PLANNING OFFICERS RECOMMENDATIONSREFUSE

THIS APPLICATION SEEKS CONSENT FOR THE CONVERSION AND EXTENSION OF AN EXISTING SINGLE STOREY SHELTER SHED ~~AND~~ ^{THE} LOCATED IN THE VALLEY BETWEEN SIBFORD FERRIS AND SIBFORD GOWER INTO A SMALL DWELLING.

LOWER LEVEL PLAN

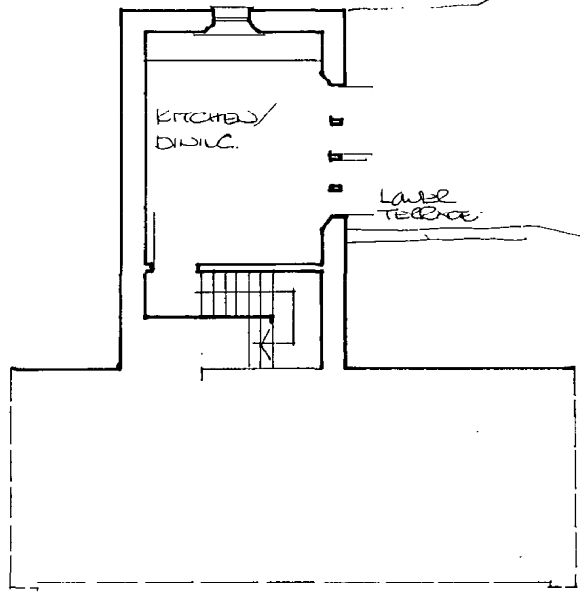
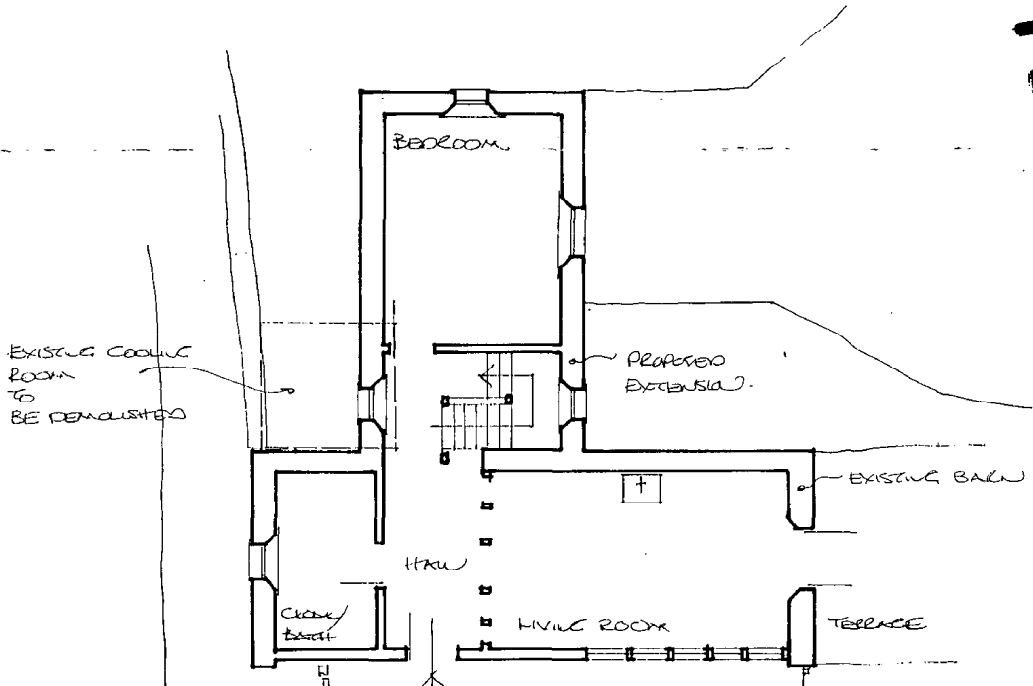
4. If the north gable window must look like a door then it should be in timber.
5. The gate should be further into the site to allow a car to be stationary when entering/exiting without protruding onto the road

8. The front would look better in stone rather than boarding. At the very least the part that is outside the repositioned gate should be in stone.
9. The steel stove pipe would be unsightly when viewed from across the valley. It needs to match its background of slate.

10. Would it not be better to have the kitchen on the same level as the living room and the bedroom below? Perhaps two small windows to the west elevation overlooking the road could then give a visual connection with the road for anyone working in the kitchen.

ACCESS IS ONTO A NARROW ROAD WITH VISIBILITY RESTRICTED BY THE ALIGNMENT OF THE ROAD AND POSITIONING OF THE EXISTING BUILDING. IN THIS LOCATION IT IS ESSENTIAL TWO PARKING SPACES AND A TURNING AREA ARE PROVIDED (THE PROPOSAL DOES NOT DO THAT). THIS WILL OR HOWEVER ~~WILL BE~~ A SIGNIFICANT LAND AREA AND HAVE A DETRIMENTAL LANDSCAPE IMPACT.
